LETTER OF INTENT: SPACE VILLAGE APARTMENTS VARIANCE OF USE

OWNER: Elite Property Group, LLC
Address: 6895 Space Village Drive
Colorado Springs, CO 80936
Parcel ID #: 54170-000-019
Zoning: CC (Commercial Community) District
Acreage: 0.628 acres

VARIANCE
SITE PLAN
V1

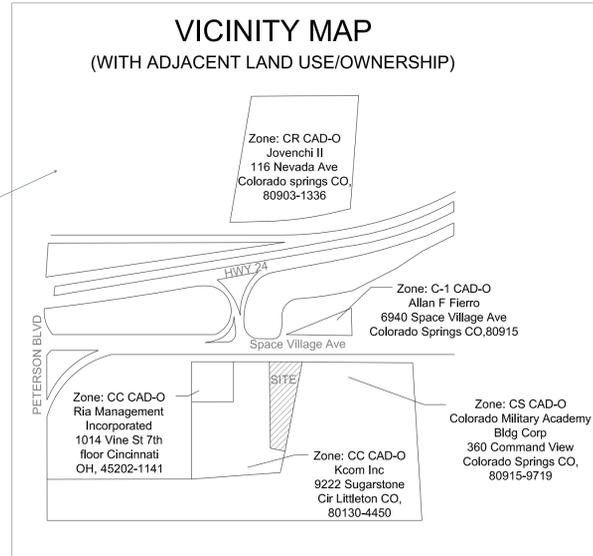
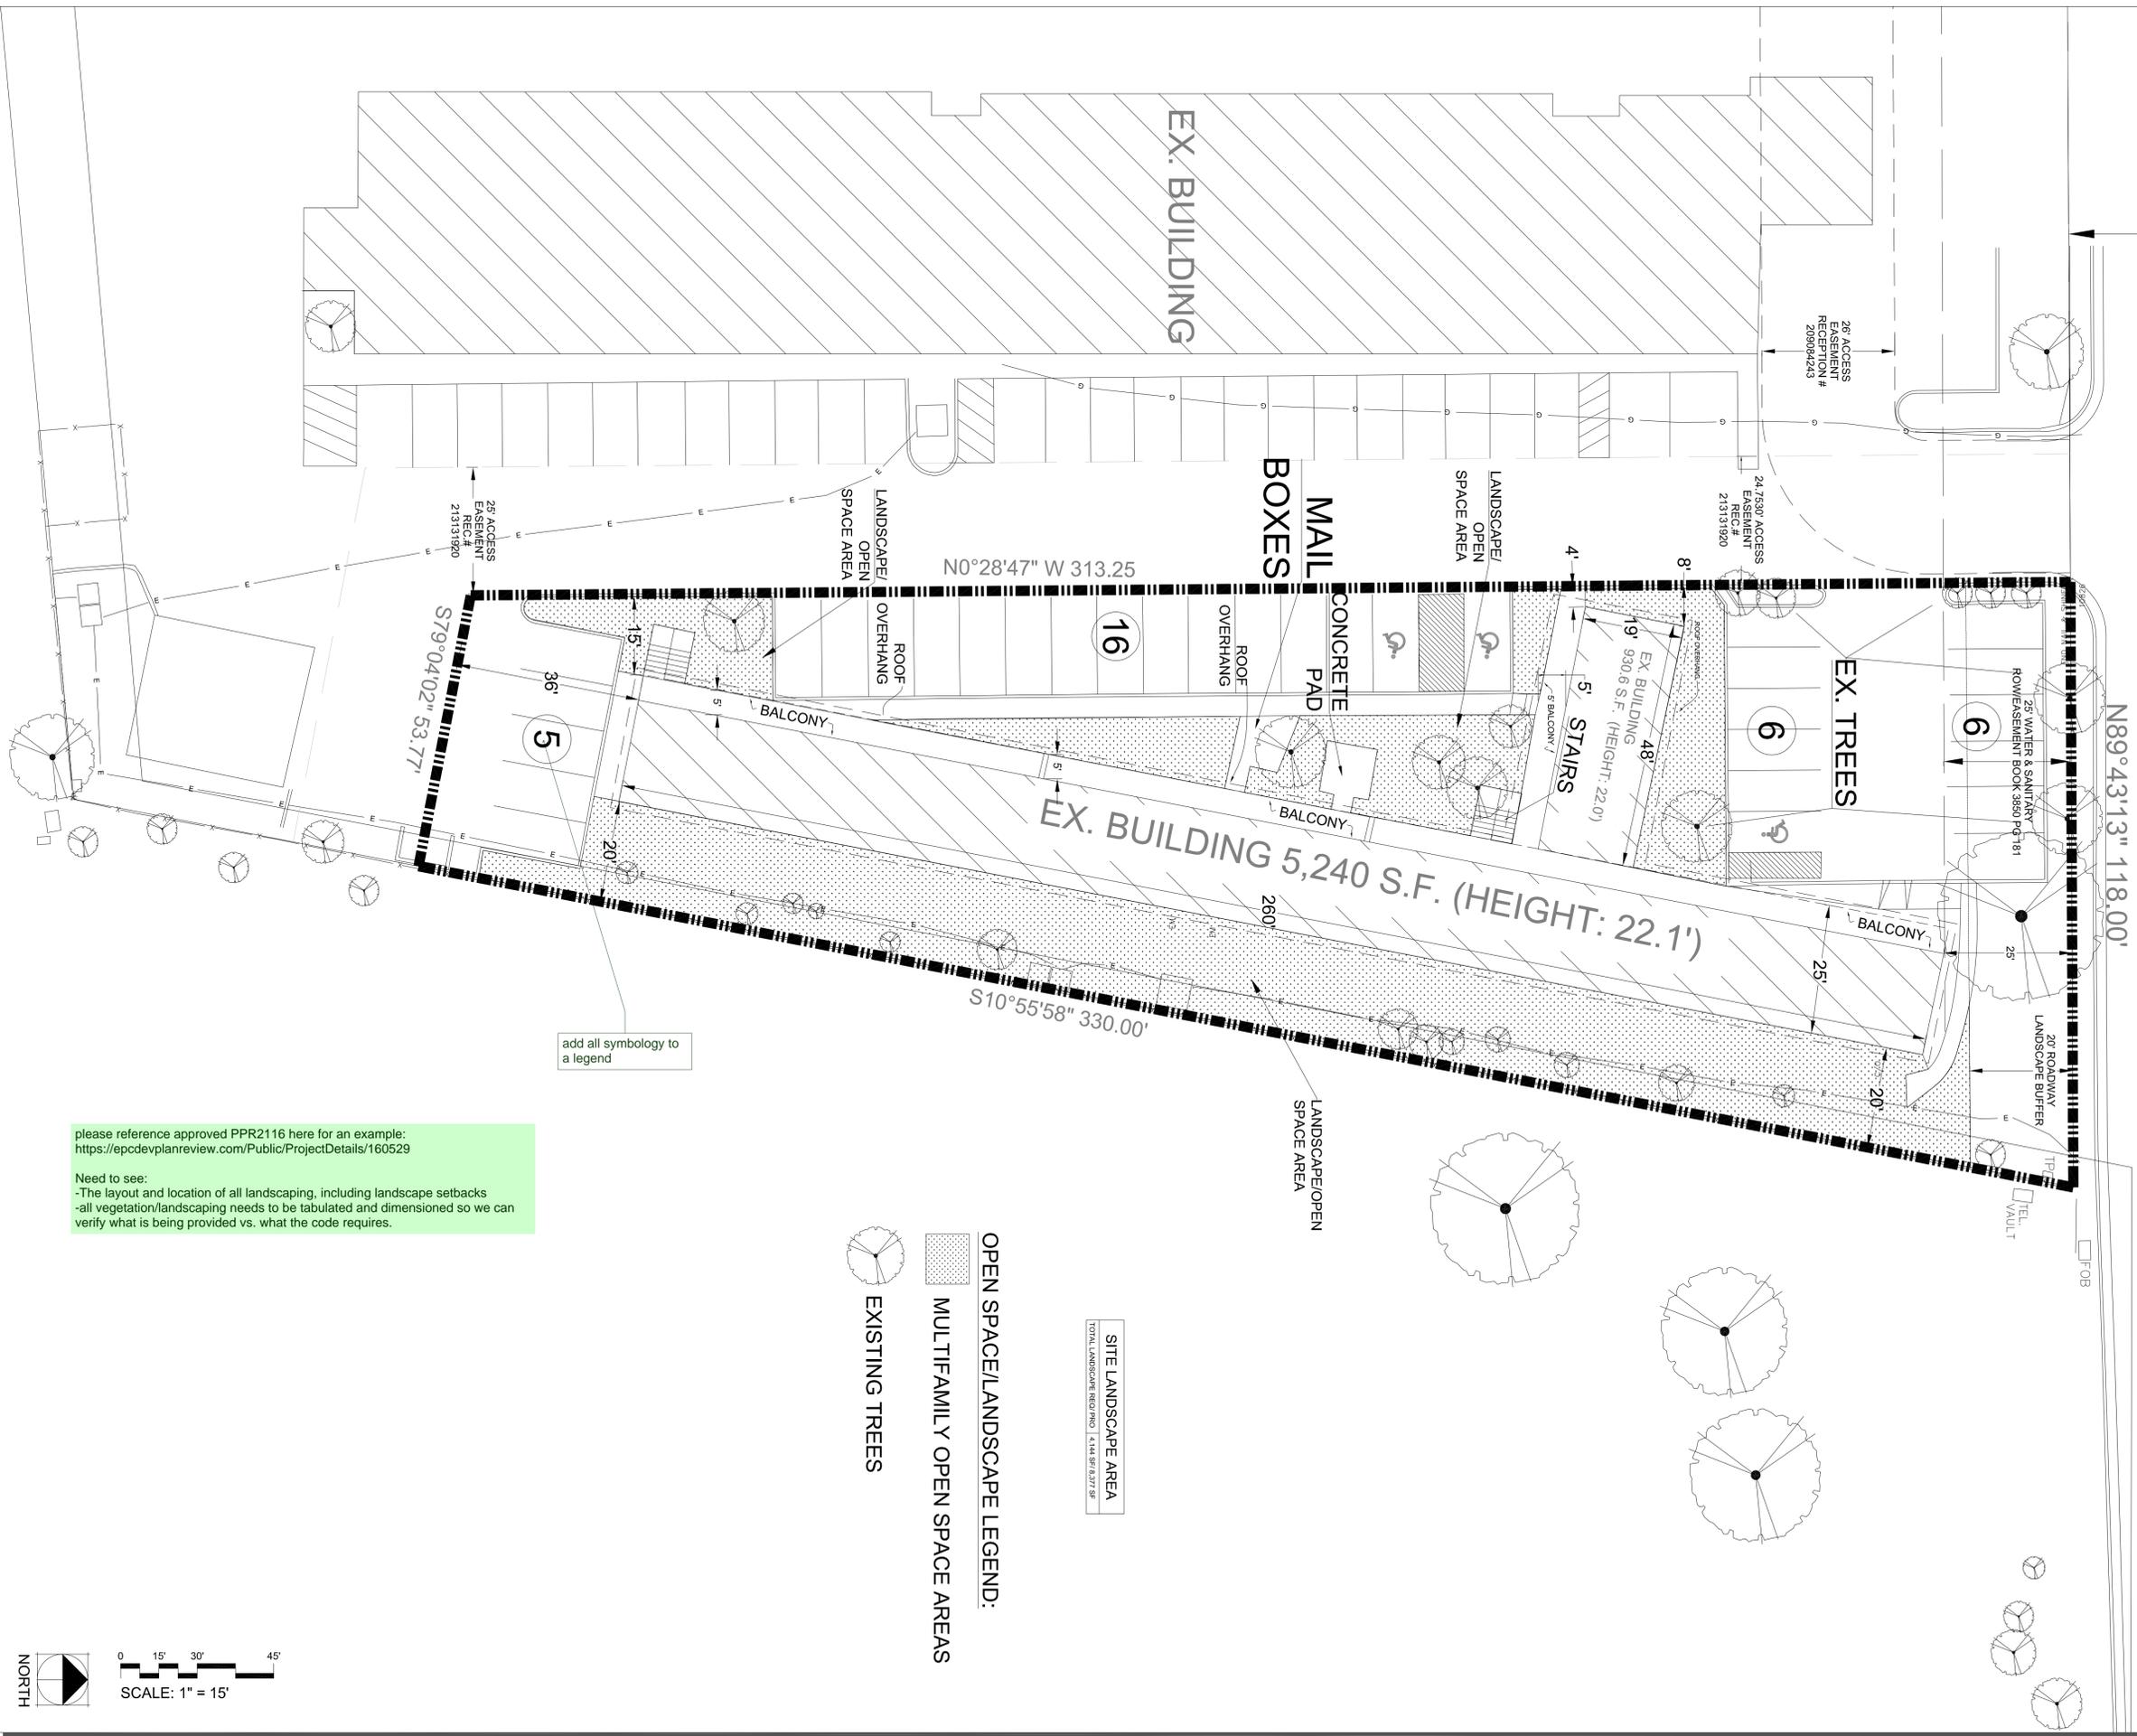
EPC is not inclined to delete the required sidewalk along Space Village Avenue. Please propose a design for the sidewalk along Space Village Ave for our review. We are open to working with you if that sidewalk should impact the existing and/or proposed landscaping within your site along Space Village.
